DEVELOPMENT REVIEW BOARD - **HYDROLOGY SECTION**

DRB Project Number: 1010999 Hearing Date: 12-14-16

Project: 3615 Hwy 528 Agenda Item No: 2

<b>DRB Case No:</b>  1010999	<b>Date:</b>  12/14/16	<b>Item No:</b>  #2
<b>Zone Atlas Page:</b>  A-14	<b>LOCATION: Tracts C-4-A, Seven Bar Ranch</b>  <b>NM HWY 528 between Ellison Dr. NW and Calle Cuervo NW</b>	
<b>Request For: 16DRB-70430 EPC Approved SDP for Subdivision</b>

SHEET 4 OF 4

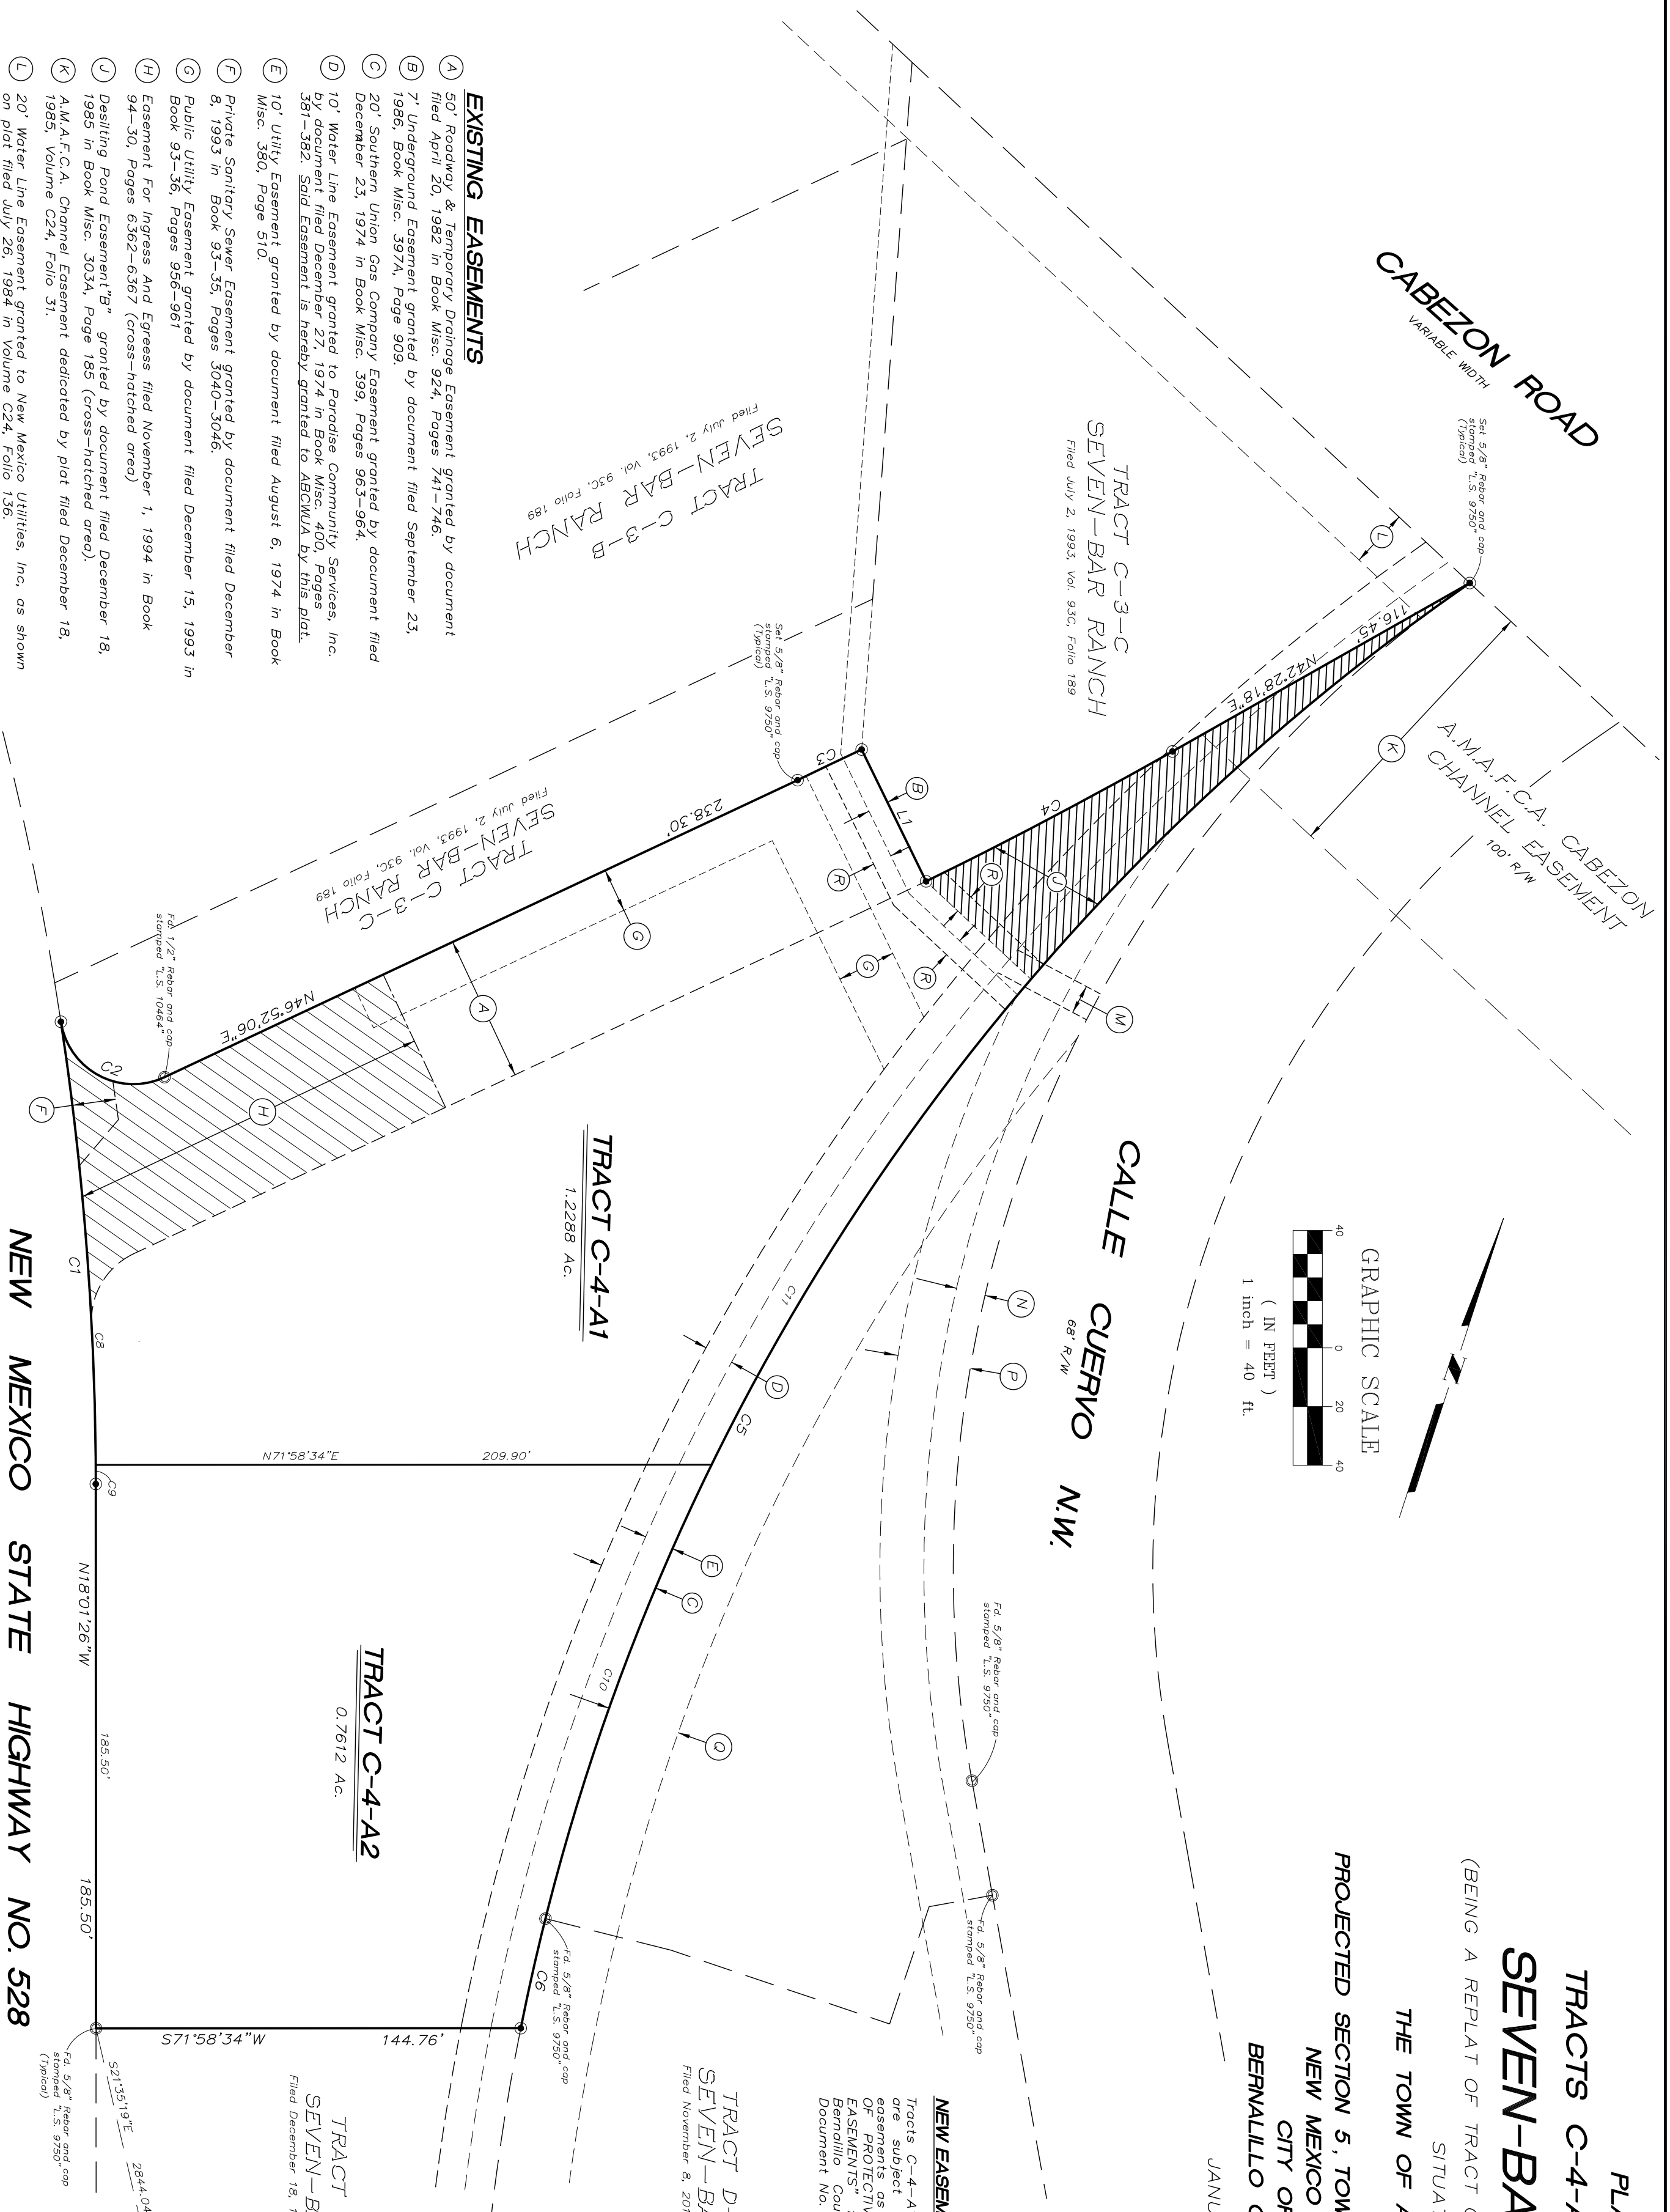
The plat will need to include drainage easements since the proposed property line will run across the water quality pond, and flows will be conveyed across the new lot line.

3. Development is outside of the Adopted Service Area so a service connection agreement is required.
4. Proposed Lot C4A and the lot with the proposed restaurant both have access to the existing 8" waterline along the eastern property line which is located within easement #3. Coordinate with 811 to determine if in fact the waterline is along the centerline of this easement or if additional easement is required.

5. There is an existing 8" waterline stub with fire hydrant located along the drive aisle north of the proposed restaurant. The site plan does not indicate an easement for this waterline, therefore a new exclusive 20' public waterline easement granted to the Water Authority is required. Coordinate with 811 to determine location of this waterline.
